From: Anita Gardner <Anita.Gardner@arun.gov.uk>
Sent: 28 February 2020 16:24
To: Planning.Responses <Planning.Responses@arun.gov.uk>
Subject: FW: K/32/19/PL Little Deerswood

From: Anita Gardner <Anita.Gardner@arun.gov.uk>
Sent: 21 February 2020 16:17
To: [REDACTED]
Subject: K/32/19/PL Little Deerswood

1703 SK126
 Little Deerswood, Kingston Gorse
 South Elevation
 Scale 1:100

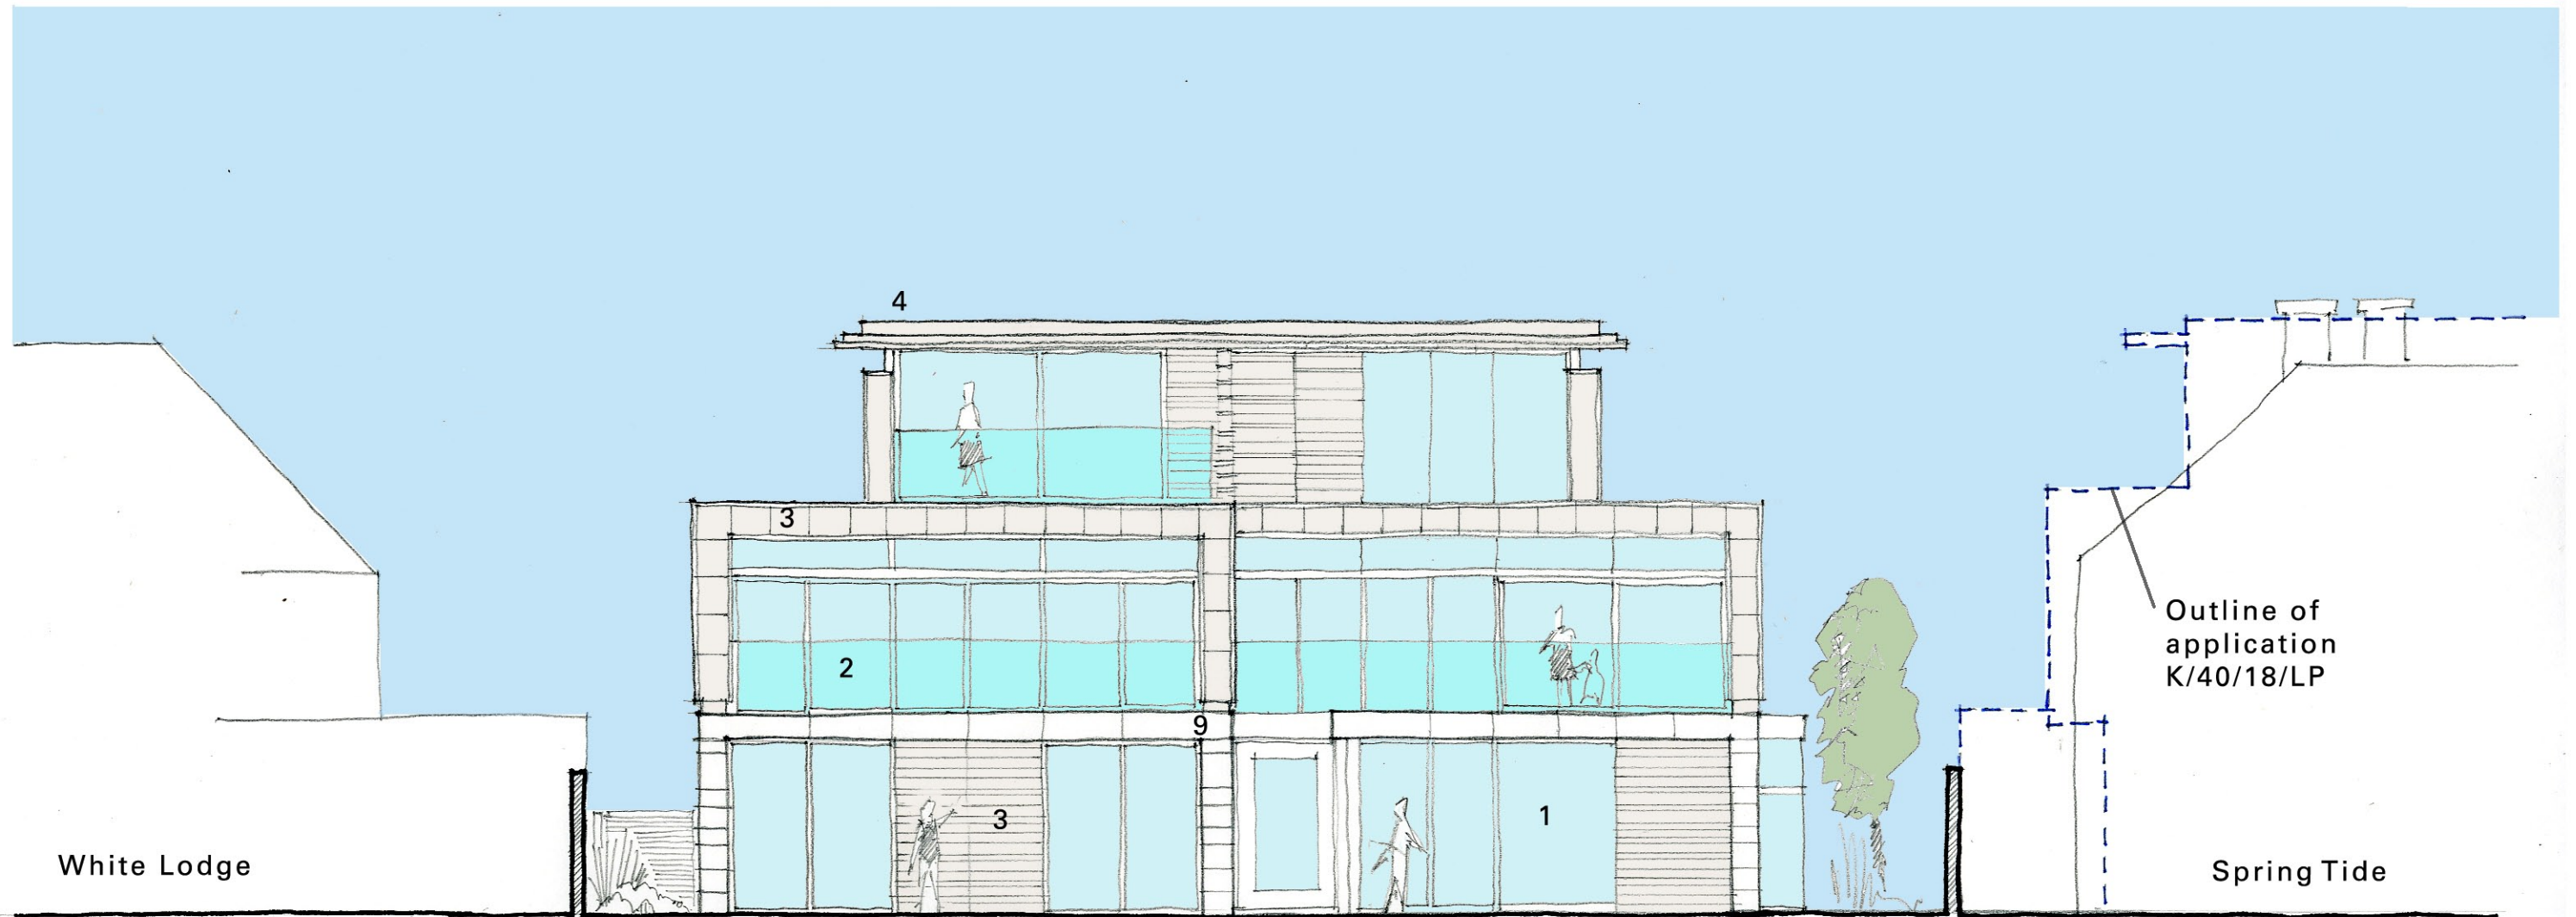
Dear Haydn,
Please can you confirm which of the samples submitted would be your preference in terms of colour and texture for the zinc roof, pre-patinated zinc cladding and reconstituted limestone?
Regards
Anita

Members have requested further details of the proposed materials. Can you let me have samples and photos of the same materials on other developments, particularly any within the local vicinity. I would appreciate receipt as soon as possible to enable consideration at Committee.

- Zinc - pigmento Rouge Terre/red. or the brown. These colour provide a softer appearance similar in tone to clay tile hanging or timber.

- Reconstituted stone – a slightly honed finish will be provided a subtle appearance similar to a buff brick (for which there are many examples in the estate) and white painted render without the maintenance issues.

Hope you received the samples and as with the majority of applications, we would provide exact samples to discharge any condition.

The both materials have been chosen for their longevity and weathering characteristic (requiring no maintenance) and that they are prominent in the area. Natural and reconstituted stone is used throughout the estate in different forms, random sandstone, dark slate, (Dolphins now Beach House), light grey High Water House, and recently approved Spring Tides scheme all on Gorse Ave. On this proposal we have chosen a lighter (white limestone) to match the white render of adjacent properties. As you know and a factor which should be taken into consideration is the amount of maintenance render requires and how unsightly it can become if not maintained, evident all the way along the sea front properties. Something we are trying to avoid here.
